KITTITAS COUNTY

MEMORANDUM

TO: All Staff
FROM: Public Works Plan Review Team
DATE: January 24, 2024
SUBJECT: BL-24-00001 Sligmann

PARCEL B SITE PLAN

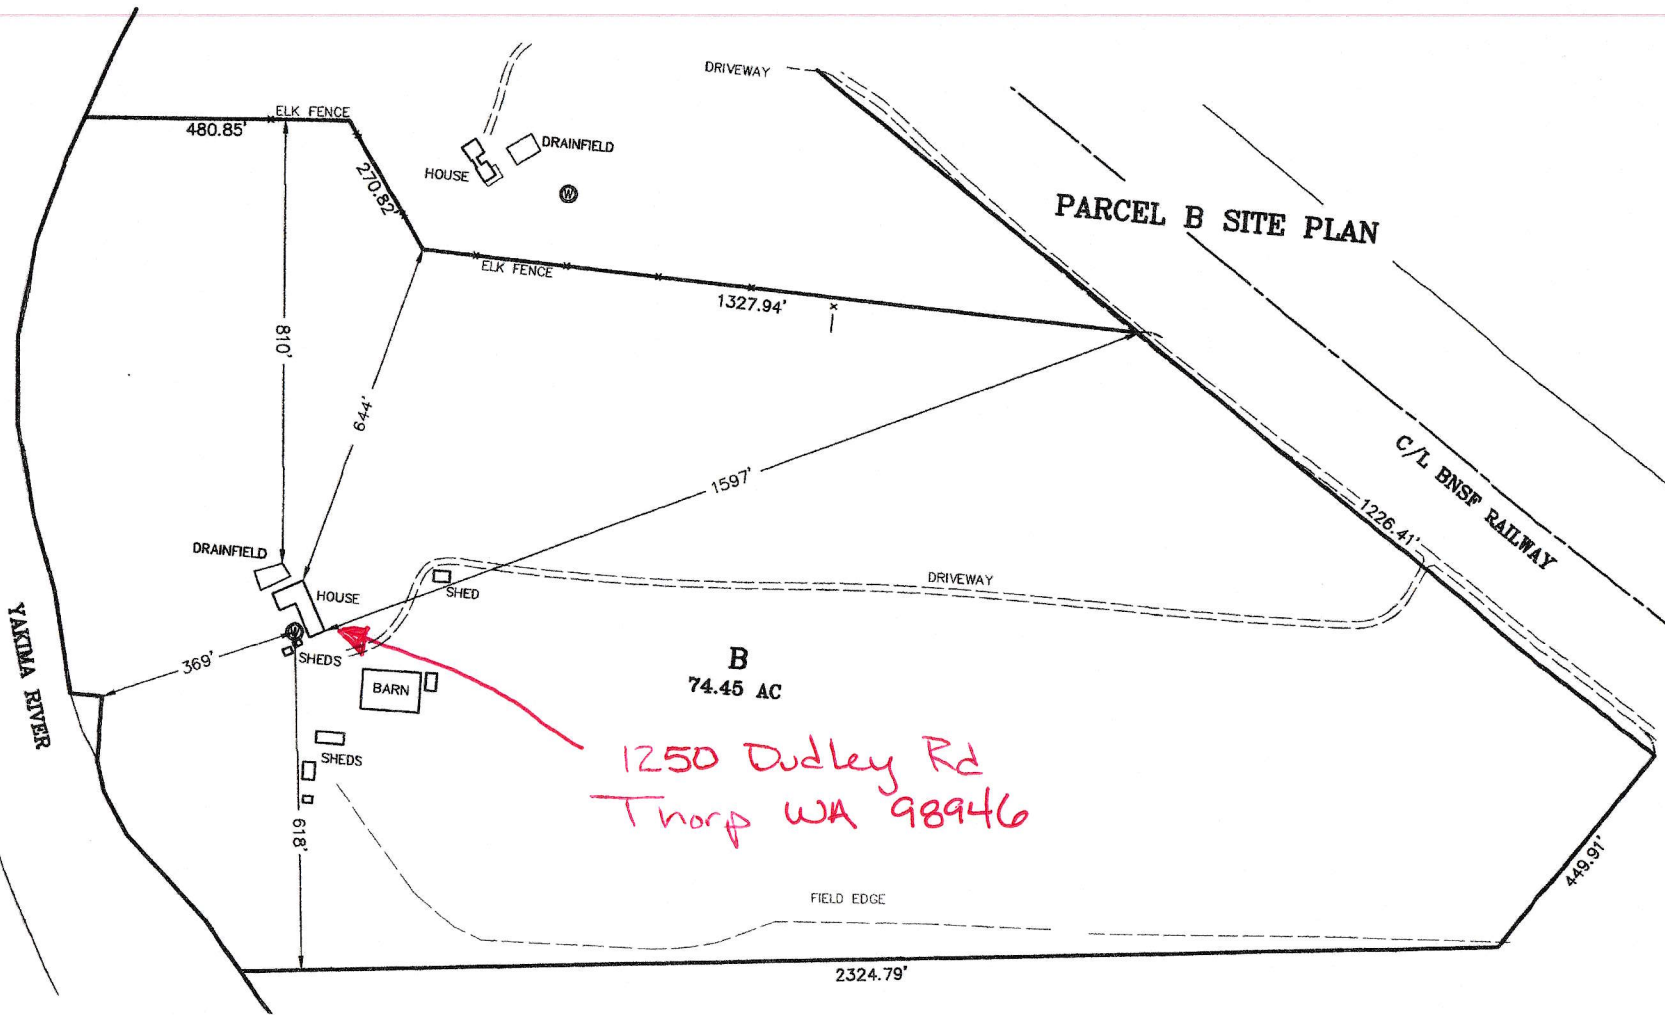
<p>ENGINEERING</p>	<p>Except as exempted in Section KCC 14.05.060, no grading or filling upon a site involving more than one hundred (100) cubic yards shall be performed without a grading permit from the County Engineer or Public Works designee (KCC 14.05.050). An application for grading in excess of five hundred (500) cubic yards shall be accompanied by an engineered grading plan (KCC 14.05.080). (CC)</p>
<p>SURVEY</p>	<p>Updated comments 02/09/2024:</p> <ol style="list-style-type: none"> 1. Fence encroachment of Parcel A northern boundary is not labeled. 2. Does the fence along Parcel A and Parcel B run the entire boundary? 3. Please show driveway on Parcel F <p>Of Note:</p>

<ol style="list-style-type: none"> 1. Does the power ped on Parcel B supply the power to irrigation circle on Parcel C? If so, utility easement will be needed. 2. There are three existing addresses for these parcels. Please note this on BLA. They as follows: <ol style="list-style-type: none"> a. Parcel A-1610 Dudley b. Parcel B-1250 Dudley c. Parcel F-794 Dudley <p>(KAH)</p> <p>Previous: As the application does not contain a survey map, comments herein reserved until final. (JT)</p>
TRANSPORTATION CONCURRENCY	No transportation concurrency is required for this project. (KAH)
FLOOD	<p>A portion of all proposed parcels are within the 100-year floodplain and floodway. The floodway is highly restricted, and any development must demonstrate no rise in the level of the 100-year flood before being permitted. No new or substantially improved residences are allowed within the floodway.</p> <p>If possible, any future development should remain outside of the floodplain in order to reduce risk and avoid mandatory flood insurance purchase requirements. All activities within the floodplain must be permitted through the floodplain development permit process and follow the regulations within KCC 14.08.</p> <p>While not required by KCC 14.08.220, it is highly encouraged that the floodplain boundaries are outlined on the face of the recorded survey. (SC)</p>
